Amended submission to Notice of Exhibition: Response to Submissions for amended concept proposal for the redevelopment of the Cockle Bay Wharf (SSD 7684)

STEVEN MEREDITH
Regional Manager, South
Heritage Division
Office of Environment & Heritage
As Delegate of the Heritage Council of NSW
9 August 2018

ENVELOPE PLAN - LEVEL 2

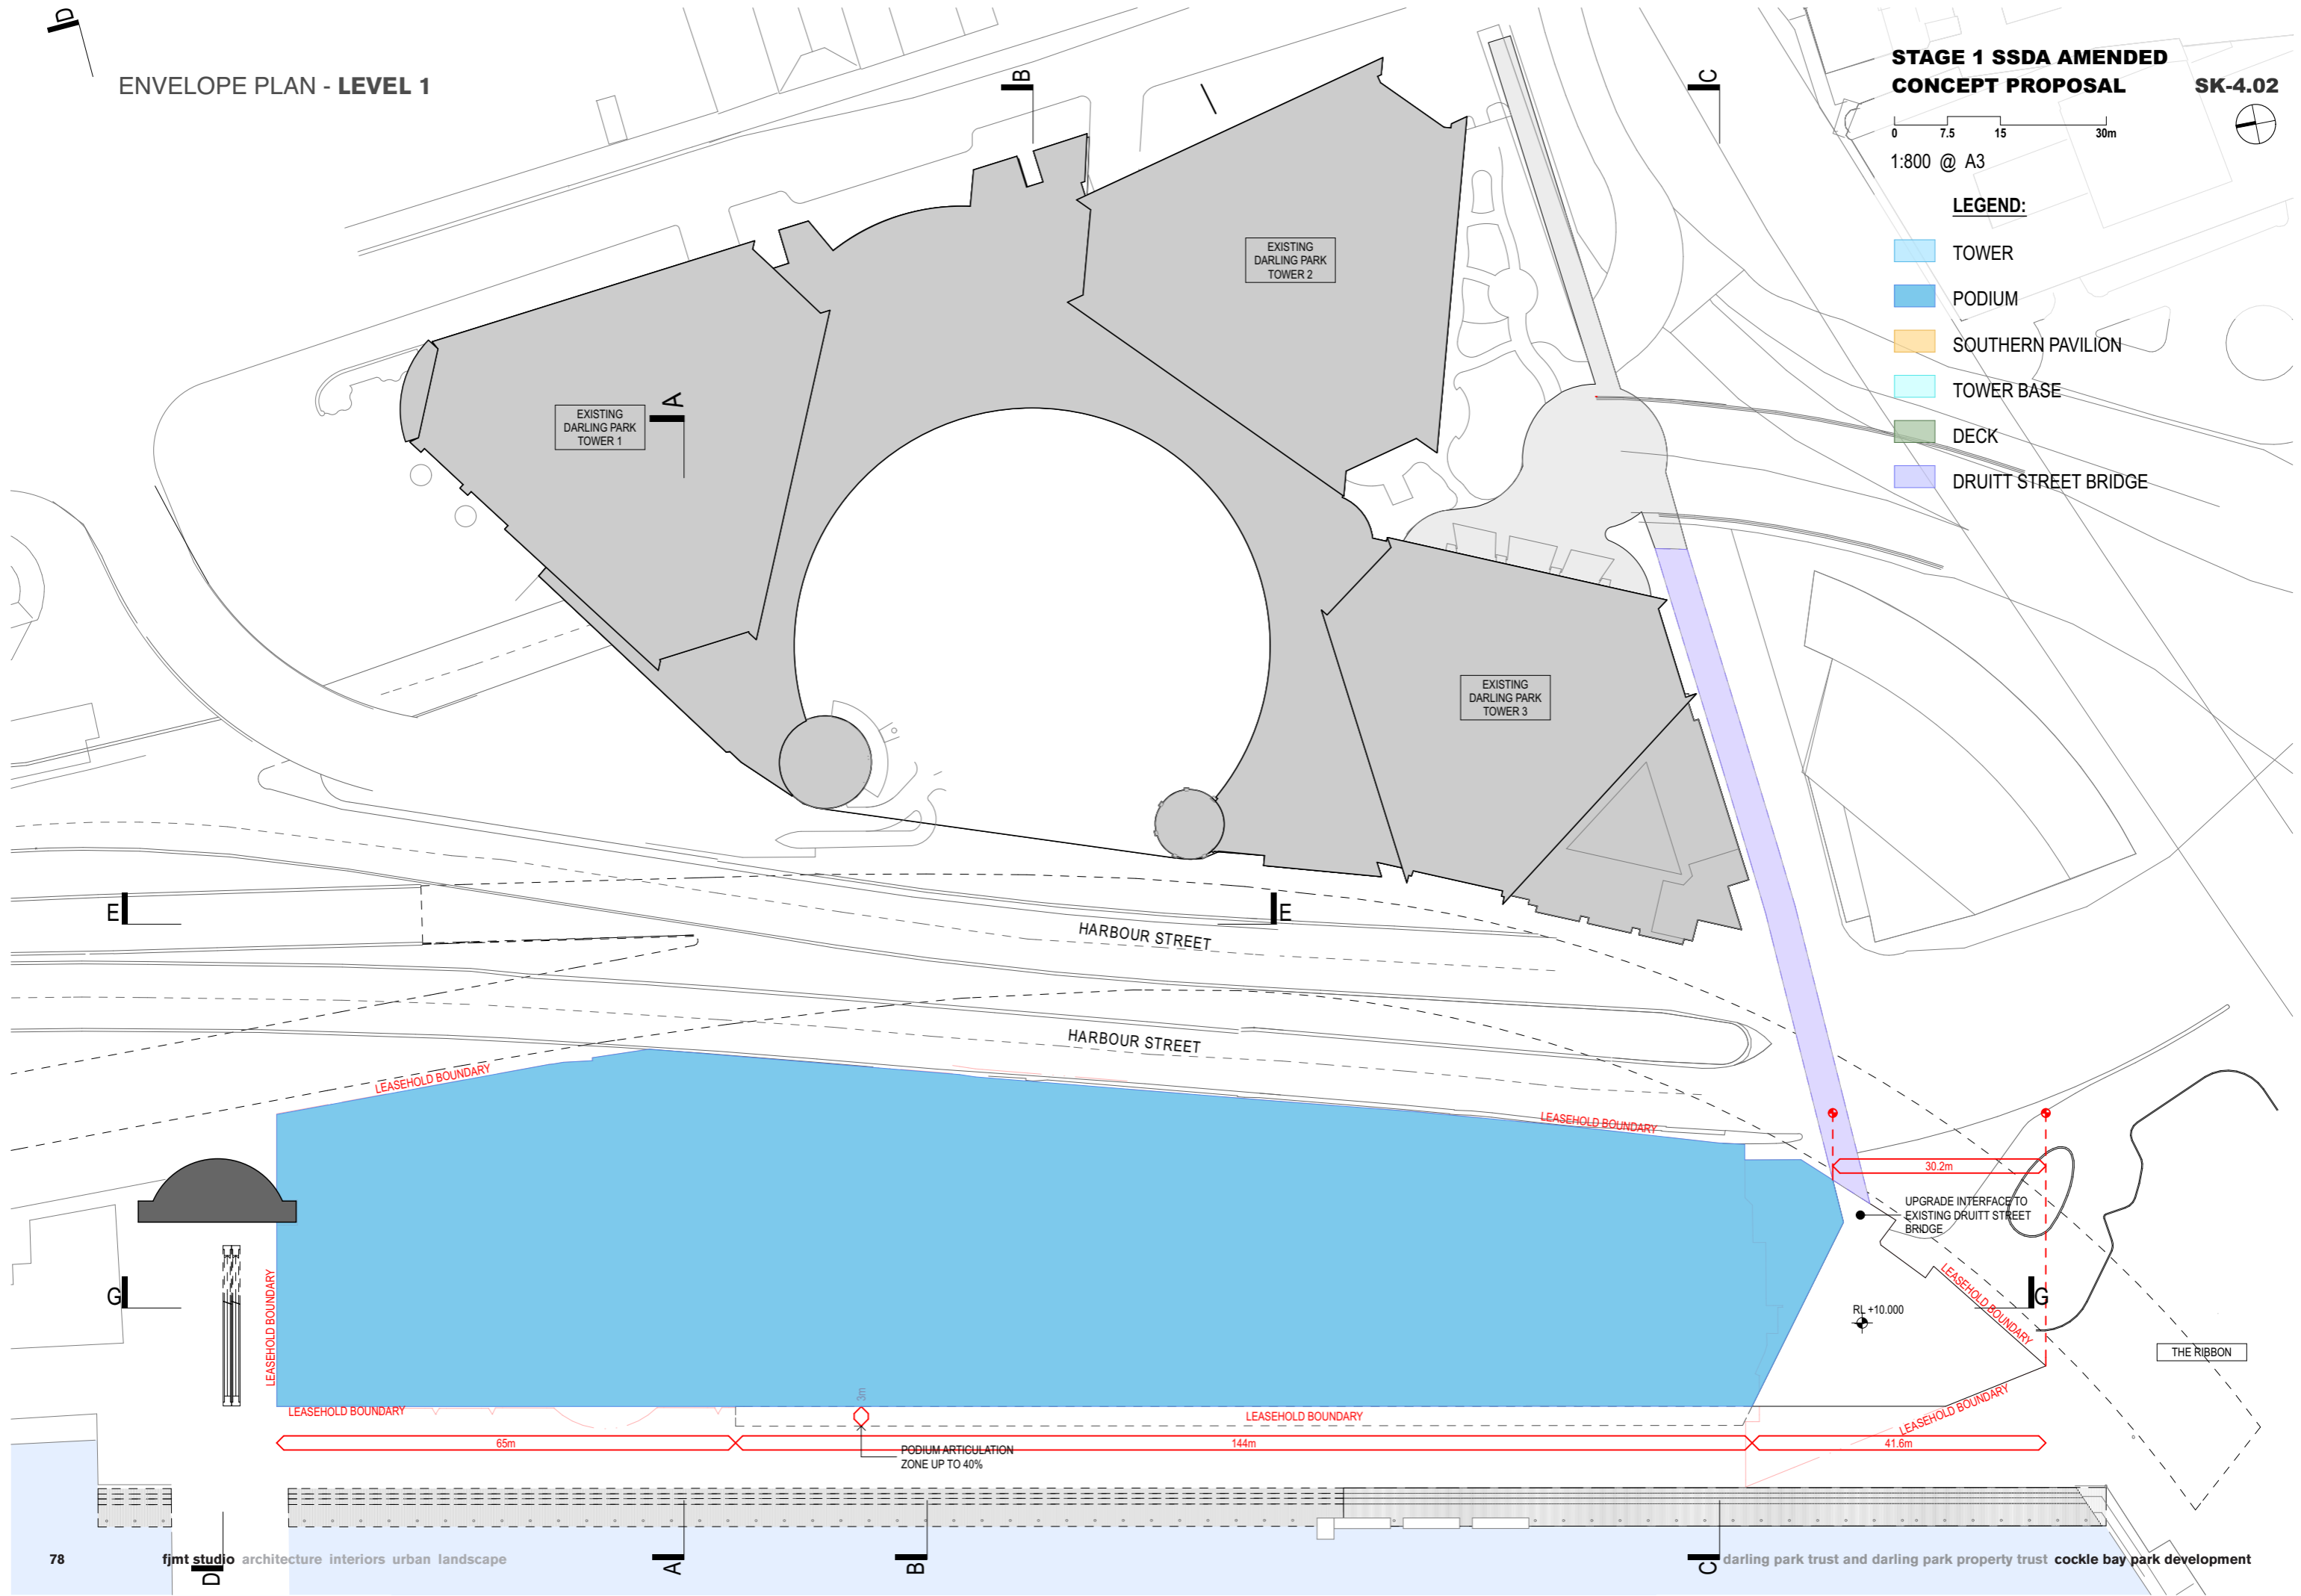
1. *The proposed new level 02 direct pedestrian bridge connection from the shopping centre podium outdoor space to Pyrmont Bridge shall be deleted to avoid visual and physical impacts on Pyrmont Bridge.*

We note that point 2 has been addressed by moving the proposed concept envelope of the tower away from the bridge. It is unclear if point 1 has been addressed, however we acknowledge that point 3 will be addressed in the detail design phase.

Both the Corn Exchange and the Shelbourne Hotel buildings present early elevations to both Sussex and Market Streets and make important contributions to the streetscape and scale in relation to other Victorian warehouse buildings along Sussex Street. The proposed elevated pedestrian deck bridge to connect Market Street to The Pyrmont Bridge will adversely impact the historic streetscape, views, and the aesthetic values of these items. Whilst the heritage report prepared by Weir Phillips Heritage addresses the visual impacts of the pedestrian bridge to the Corn Exchange building and indicates these are acceptable, it does not address the impacts to the Shelbourne Hotel. We disagree with this assessment and recommend that the location of the proposed bridge should be modified to minimise the visual impacts on these items.

12. The proposed location of the new pedestrian bridge to connect Market Street to the podium and Pyrmont Bridge should be reviewed to avoid visual impacts to the Corn Exchange building and to the Shelbourne Hotel.
